SWPPP COMPLIANCE INSPECTION REPORT

| Project | Coors Village Offsite |
| Location | Western Trails and Coors Blvd |

| Inspection Type | Rain Event Inspection |

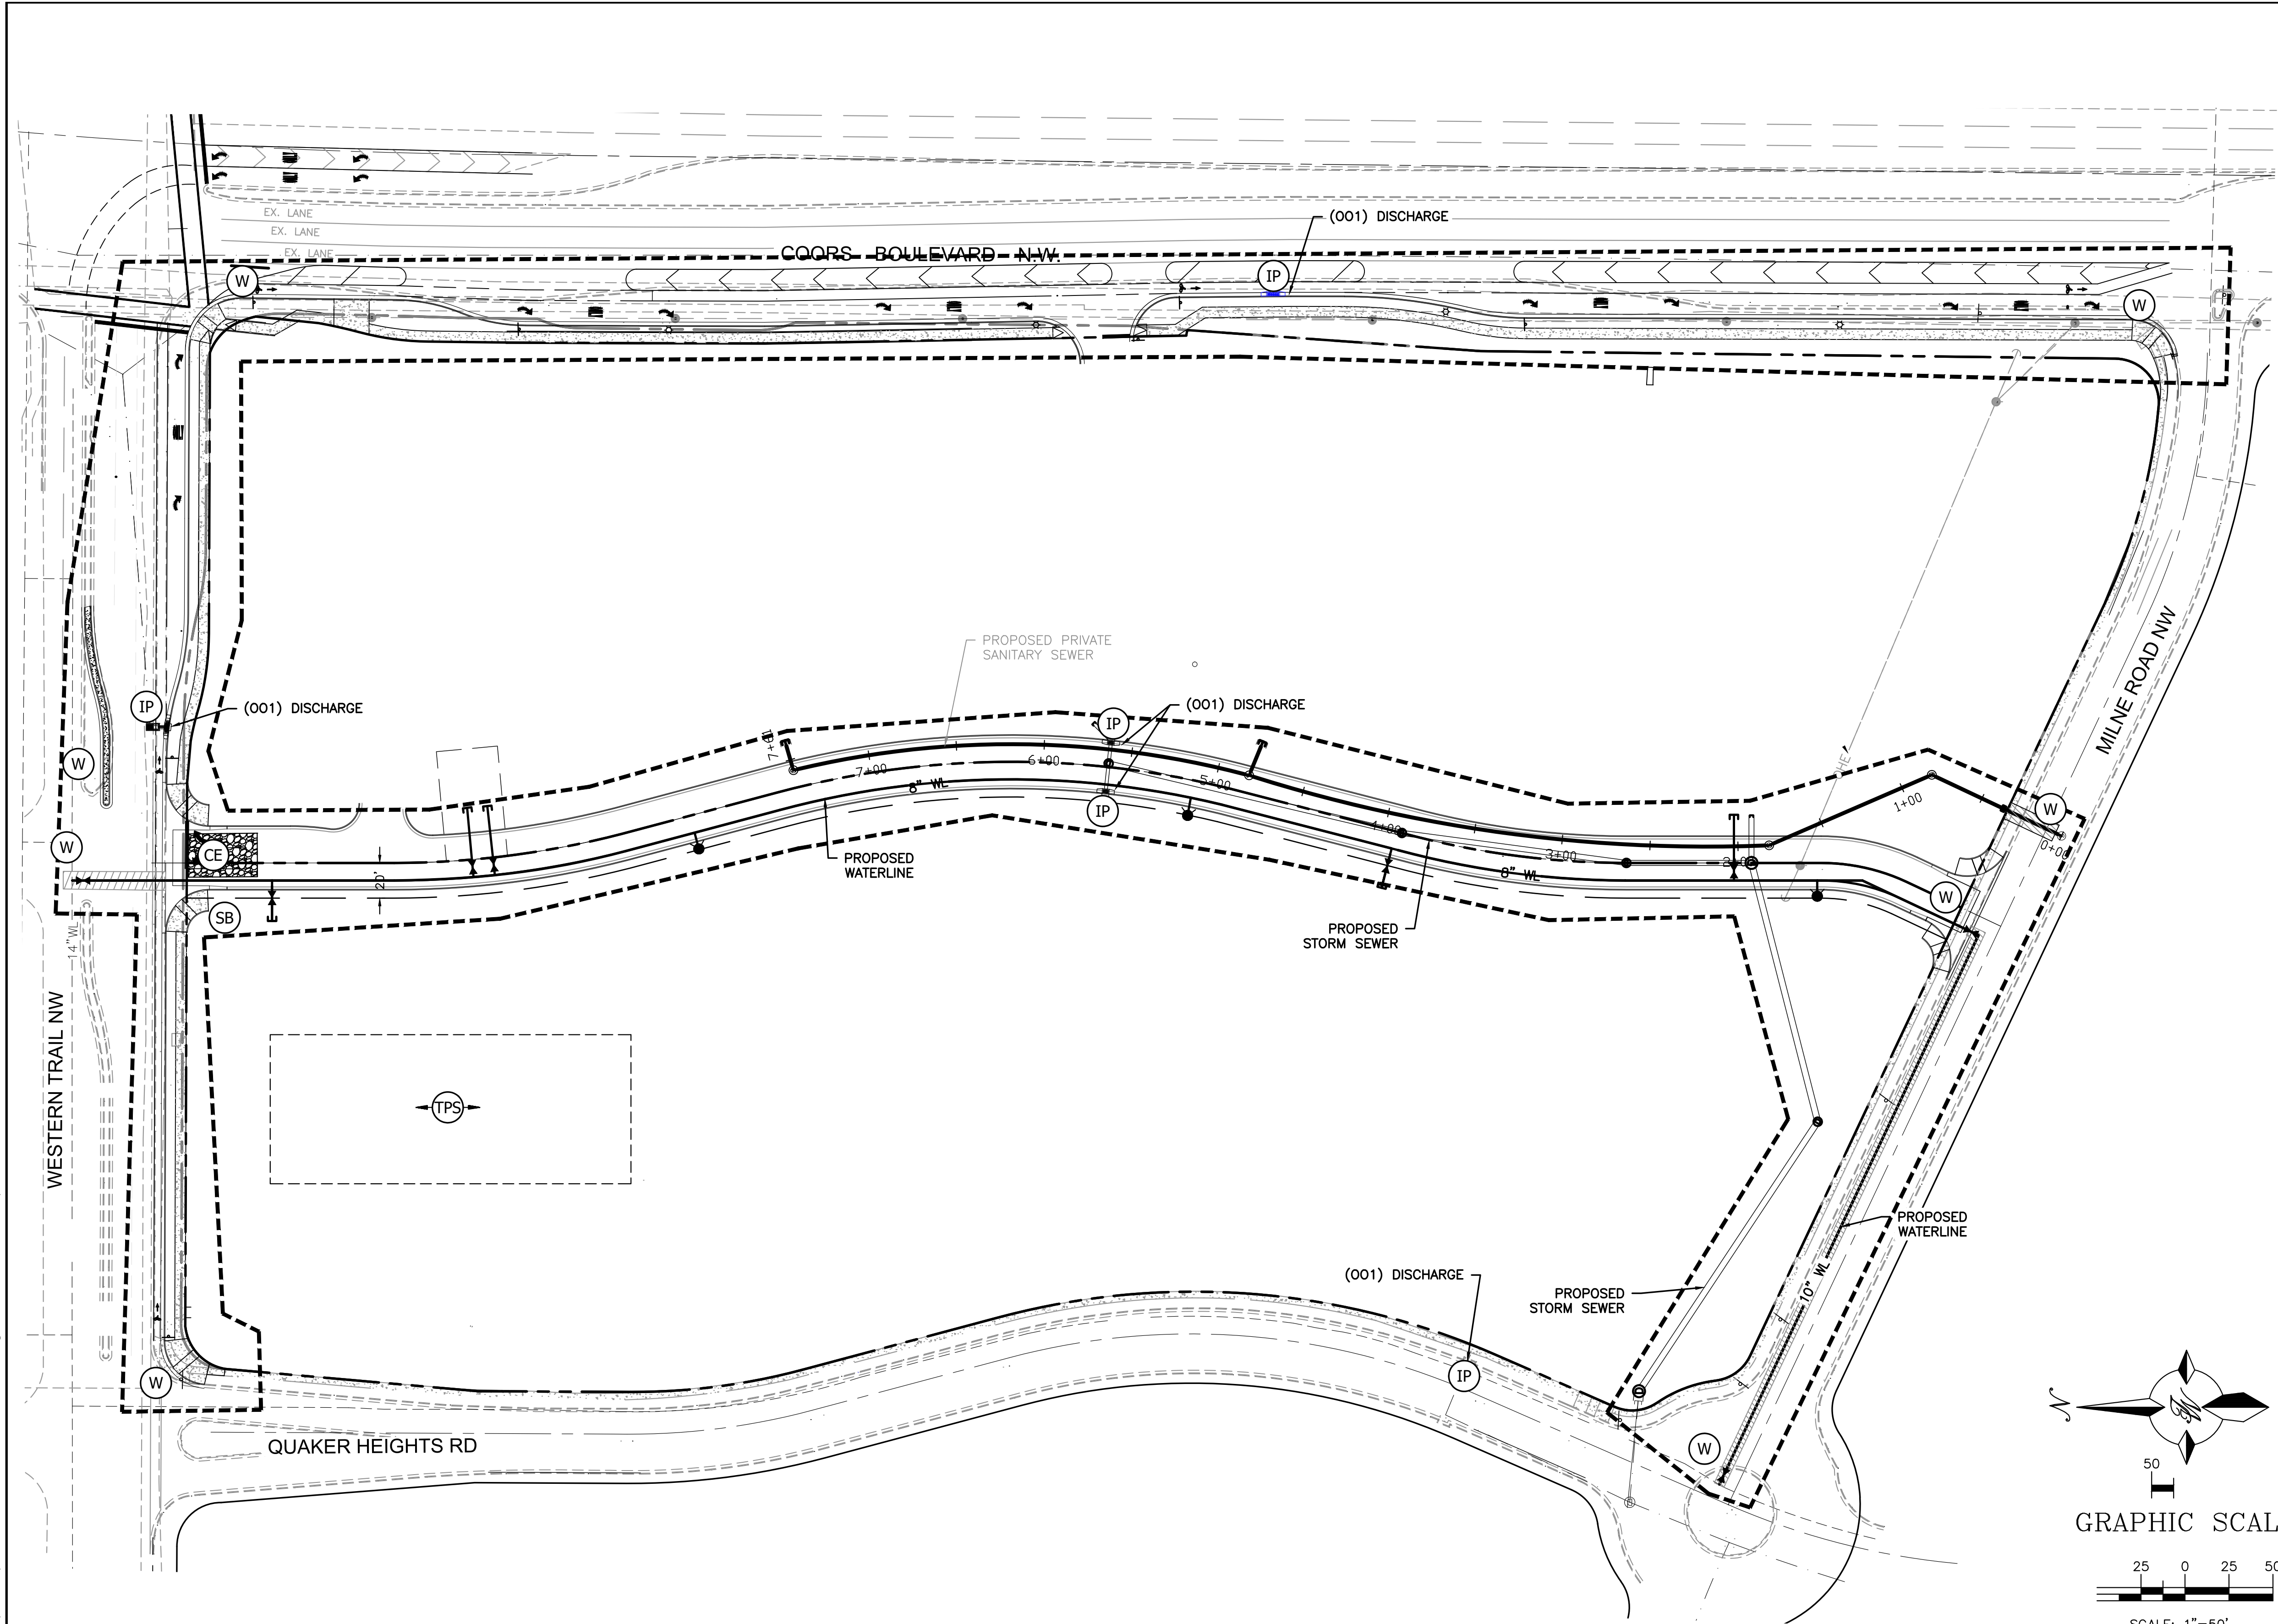
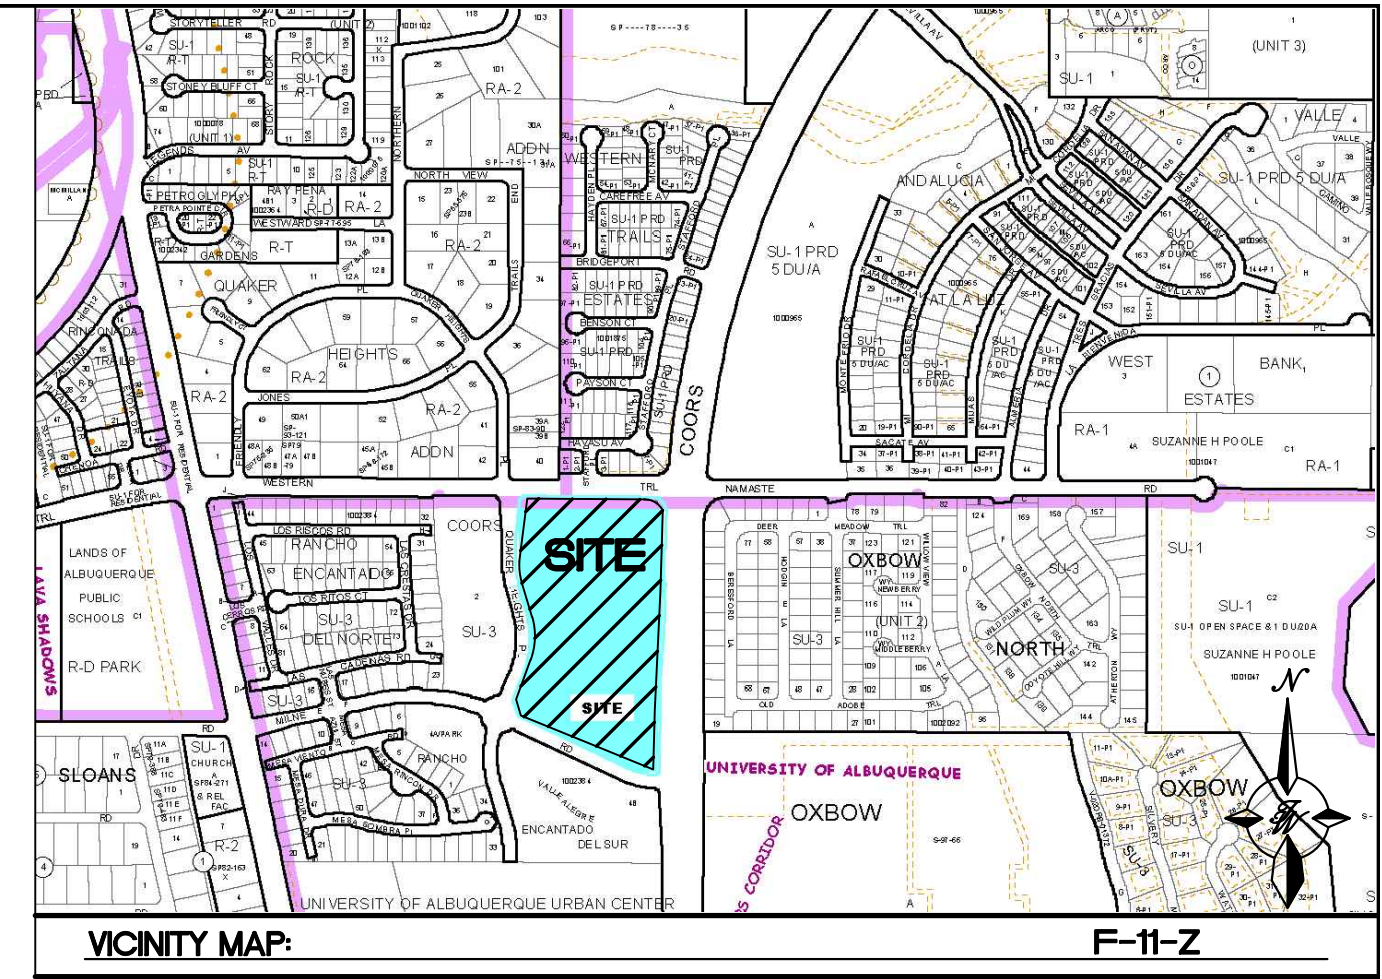
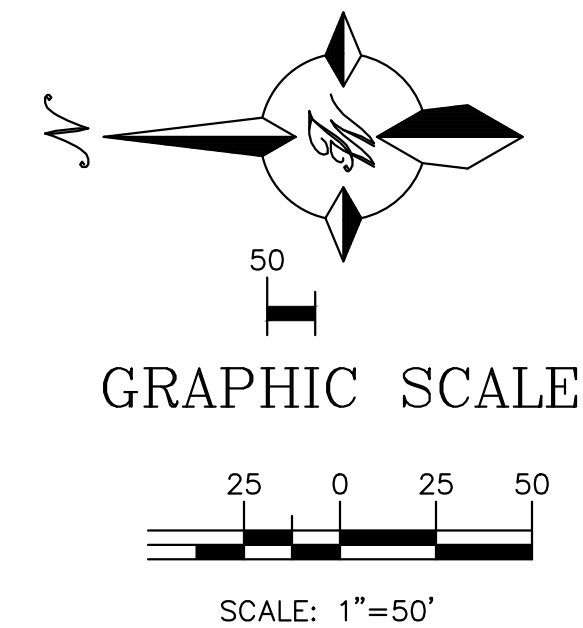
| SITE INSPECTION OBSERVATIONS | | | |
|---|-----------|---|---|
| Are the Limits of Disturbance properly protected? | No | Repair Silt Fence/Wattles | Silt Fence along west side of future roadway is falling down. Wattles on Quaker Heights Rd have been flattened. |
| Are Construction Exits properly controlling sediment track out from the site? | No | Install Stabilized Construction Entrance/ Continue to sweep work areas and exits clean of sediment daily | Track out and flattening of wattles observed on Quaker Heights Rd just north of Milne. If this area is being used as a construction access, a stabilized entrance and sediment trap is required |
| Are Inlets and Water Quality Device properly protected from sediment? | No | Add inlet protection | Inlet east of construction entrance along Western Trails needs to be protected |

| Are there any changes to the SWPPP required? | No | None | Restrict access to only protected entrances /exits |

| POLLUTION PREVENTION, SEDIMENT AND EROSION CONTROLS | | | |
|--|-------------------|-----------------------|---|
| Wattle | Quaker Heights | Track out/ Flattening | Install stabilized entrance and sediment trap |

| INSPECTION COMMENTS OR OTHER |
|--|
| <p>Restrict access to controlled entrances and exits</p> <p>Sweep track out daily.</p> |
